Planning Application Ref: Y/52/17/DOC (prev Y/5/16/PL)

Location: Longacre, Maypole Lane, Yapton

Description of works: Seeking discharge of Conditions

Drawing title: Tree Protection Plan

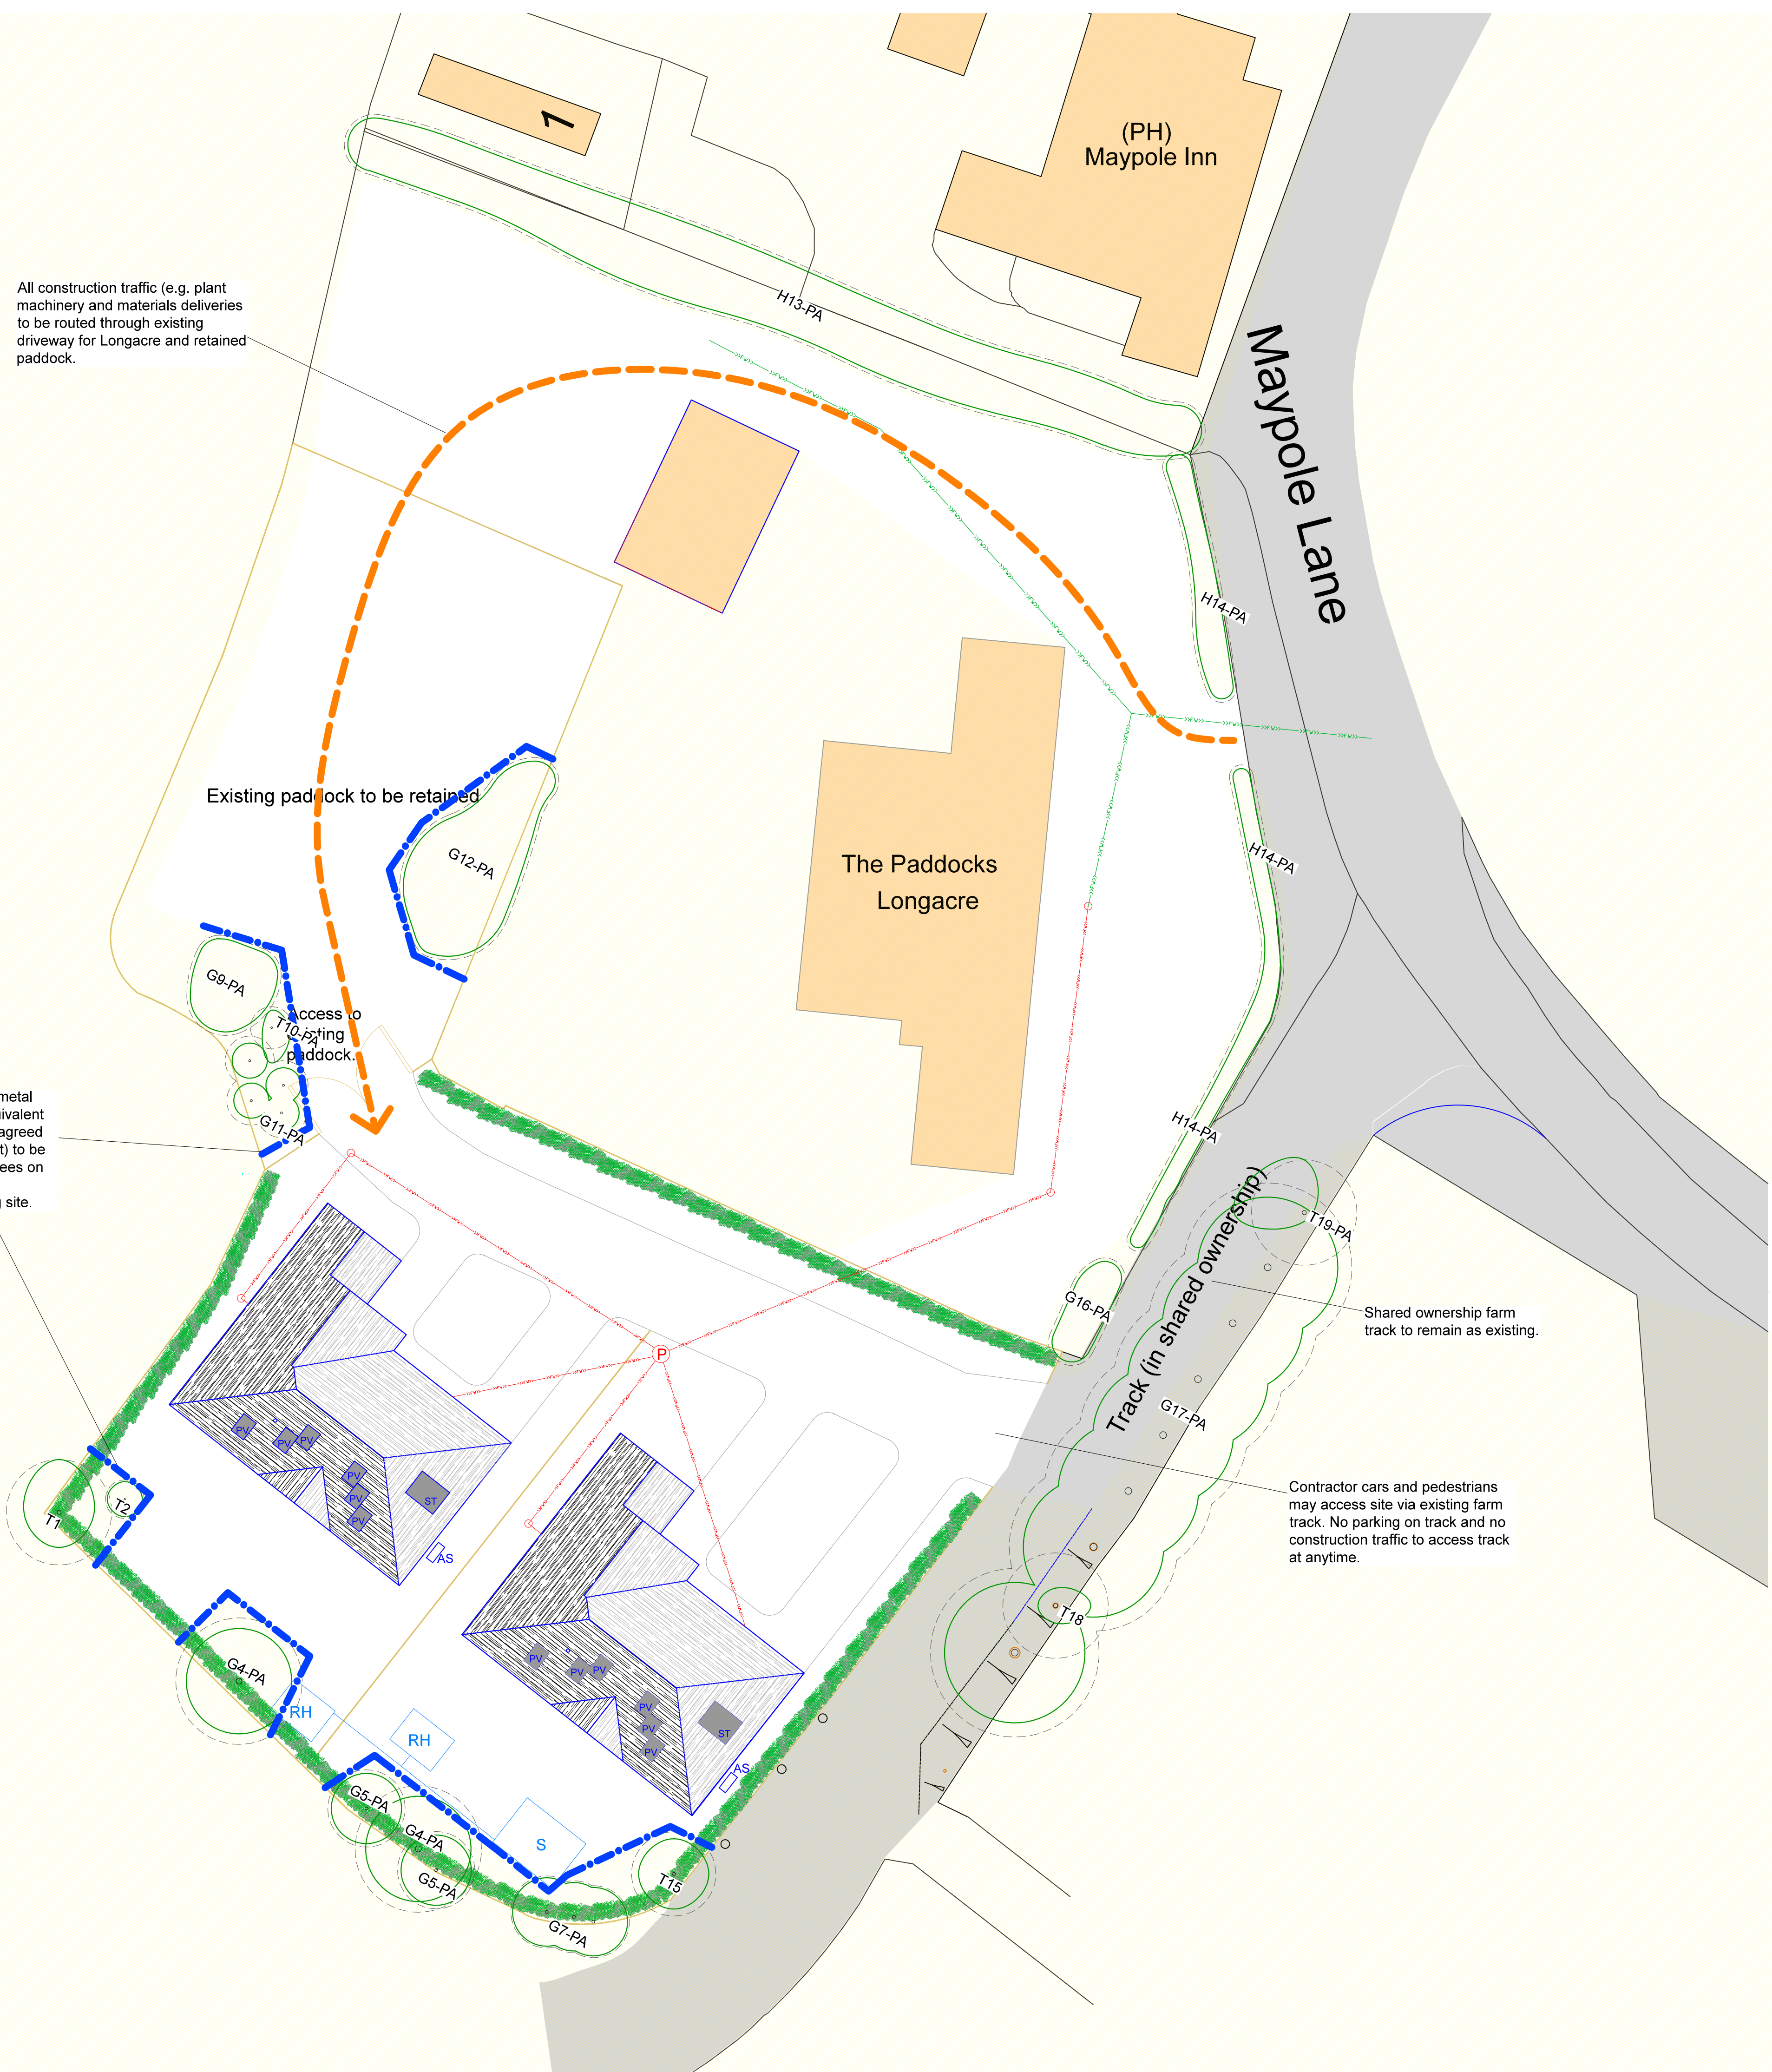
- The Condition relating to tree issues is No 5 which reads '*No development including site access, demolition or associated construction activities shall take place unless and until all the existing trees/bushes/hedges to be retained on site have been protected by a fence in accordance with BS5837 (2012)...*'
- The PJC Consultancy Tree Protection Plan PJC/4366/17/B – 24/03/17 is the plan to be complied with in this respect.
- I inspected site and noted that there is no protective fencing erected anywhere on the site and development has not only been started but it is well under way with foundations already dug and in place.

- I am unable to sign off on a Condition which has not been complied with.

- As far as I can see they are in breach of a Planning Condition and this is a matter to be referred to the enforcement team for further investigation and appropriate action.
